Addendum No. 1

RE: Contract # C204192
WBS # 2019CPT.13.01.10111, Etc
STATE FUNDED

1 Section Each of NC 63, US-25A, NC-197, 3 Sections of NC9
And 87 Sections Of Secondary Roads

June 19, 2018 Letting

PROJECT NO.	SHEET NO.	TOTAL SHEETS
2019CPT.13.01.10111, 2019CPT.13.01.20111 2019CPT.13.01.20112	11A

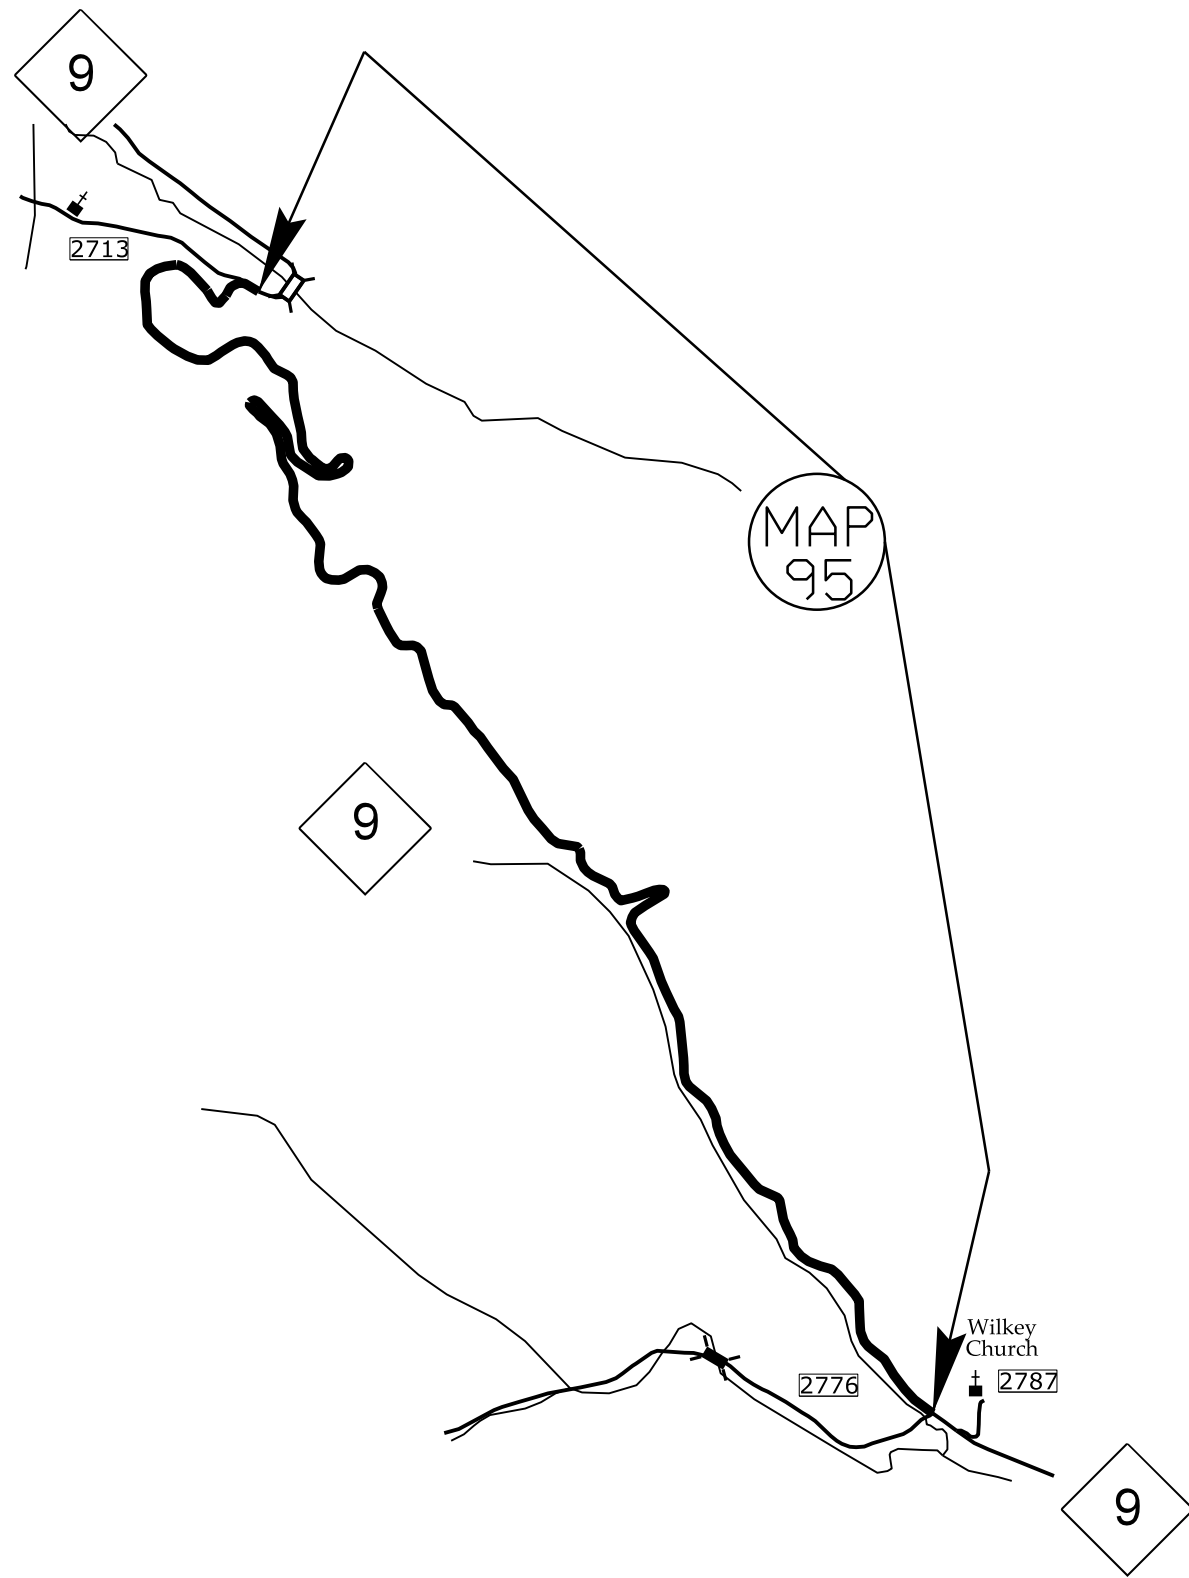
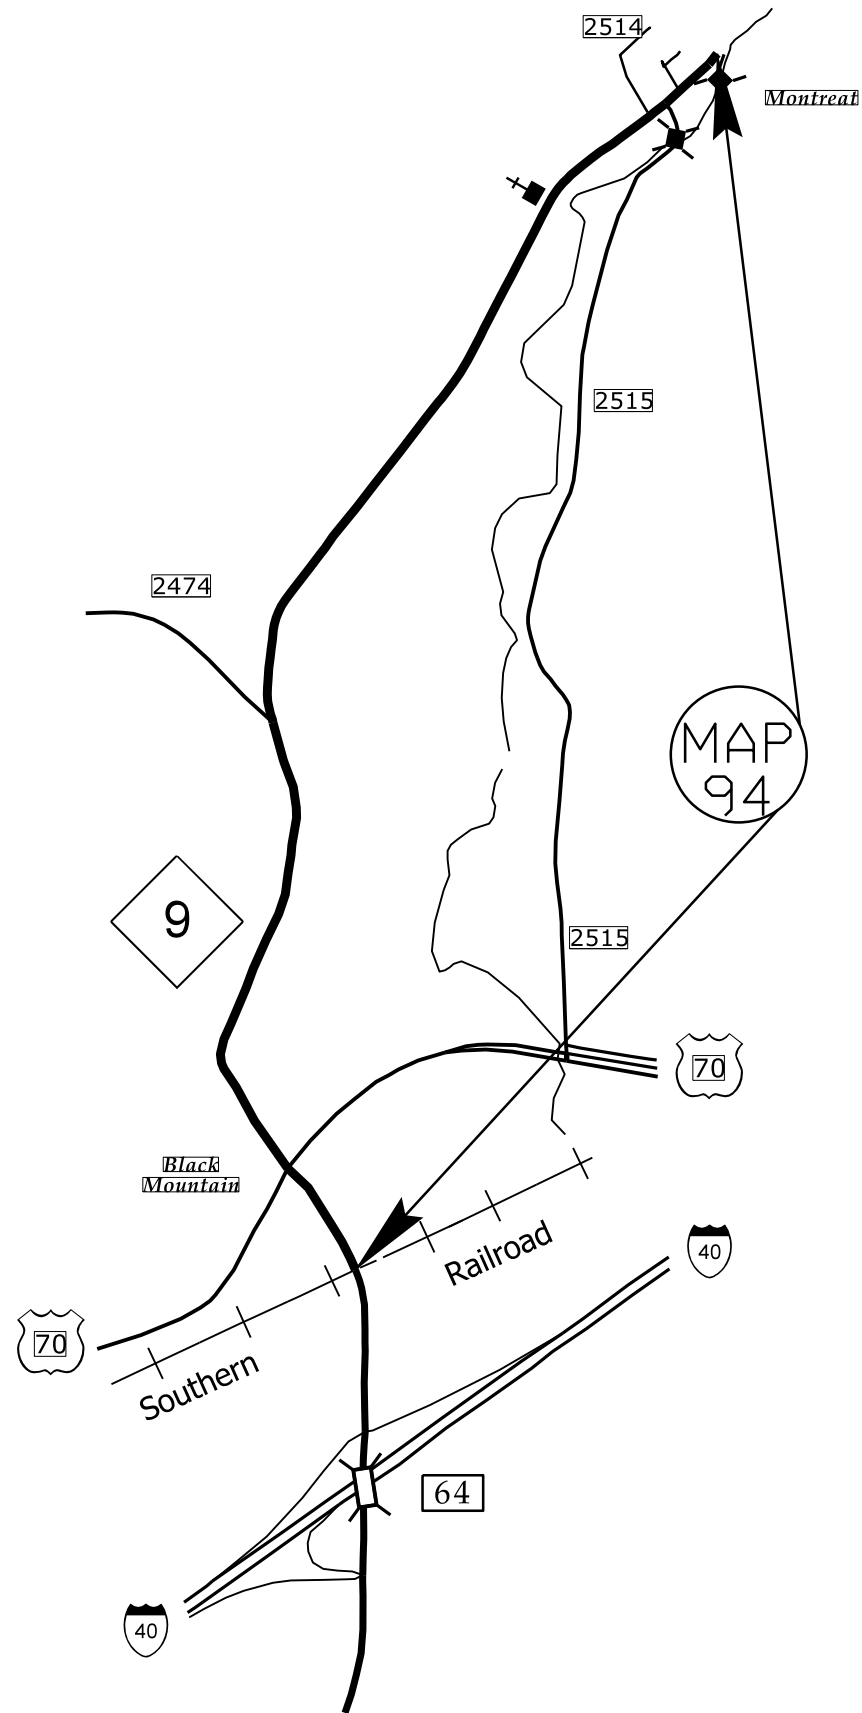
Sheet No.	Revisions
1	Revised to eliminate Map #1
New 11A and 11B	New sheets to add Map # 94, 95 and 96
12	Typical Section Nos. 1 and 2 were removed
14	Revised dimensions on Typical Section No. 5
21	Updated bridge details to remove reference to Map #1 and add information for Map #96
22	Removed a detail pertaining to Map #1
24 thru 27	Updated Summary of Quantities to reflect the changes as noted above and as noted below on the item sheets
